****** FIELD CHANGE LETTER ******

PROJECT #: 22-1192-B (Lot 21, Duncans Creek)

PLANS REF: Wilson Plan (Garage Left) by New Home, Inc Project #: 22-1192 sealed 11-9-22

S-2.1

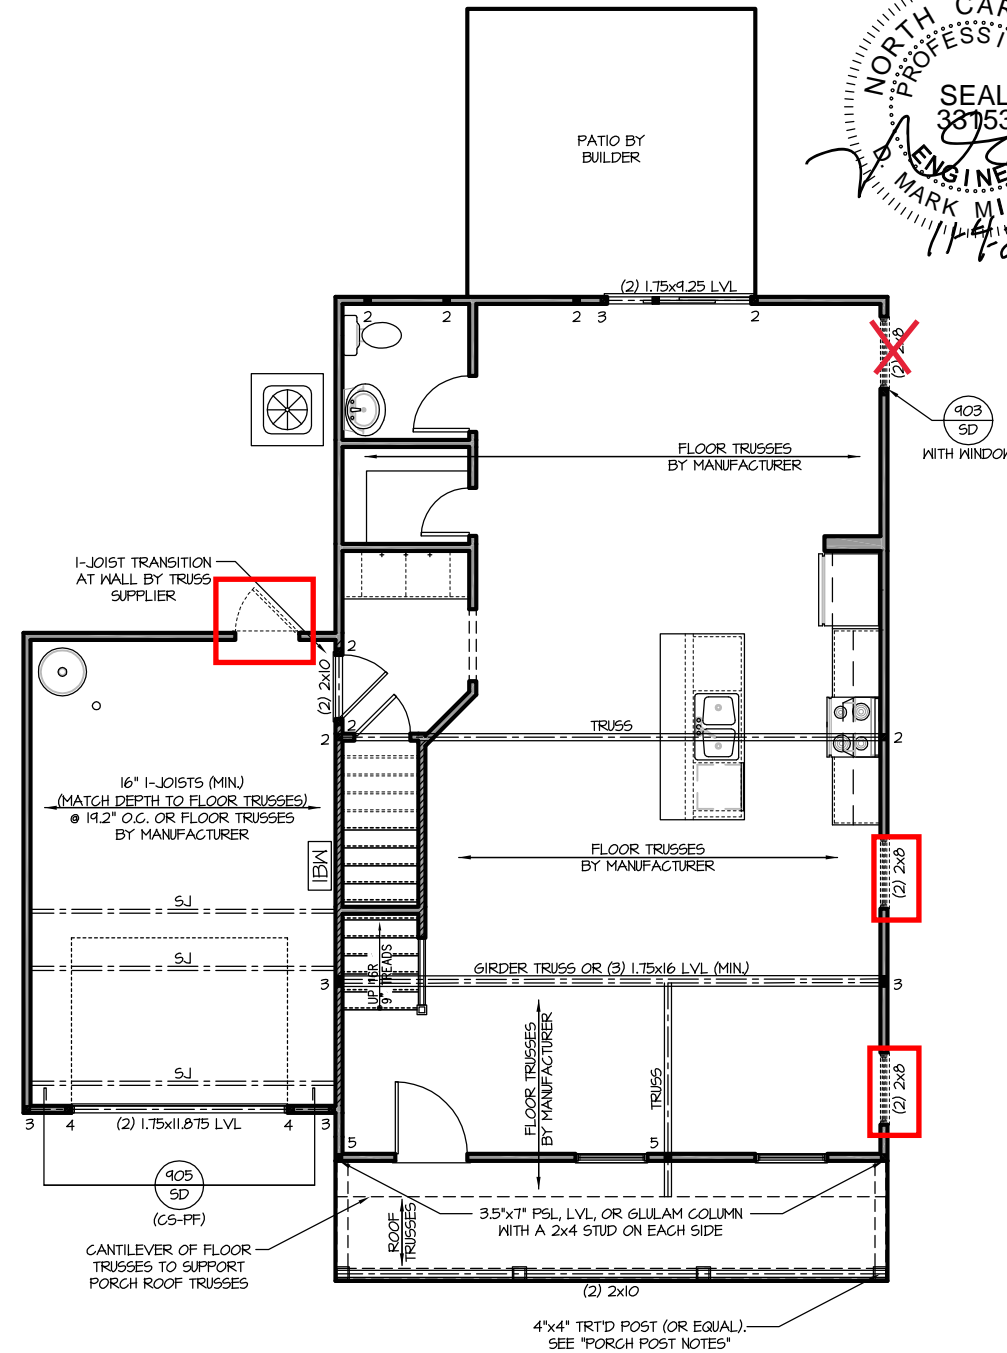
Notched PSL column: Sheets S-2.1 of the plans for Elevation C shows a “3.5”x7” PSL or glulam column with a 2x4 on each side” at the front corners of the house. Based on information provided to Southern Engineers, the back side of the bottom edge of the right PSL column was notched with an approximately 1” wide strip due to an anchor bolt. The PSL column is bearing directly on a 2x4 treated sill plate. A 2x4 stud was not installed on the back side of the PSL column.

Response: Please note that the above noted notch in the bottom of the PSL column will be structurally acceptable provided that a 2x4 stud is installed on the back side of the PSL column and attached with (2) staggered rows of 12d nails at 8” O.C.
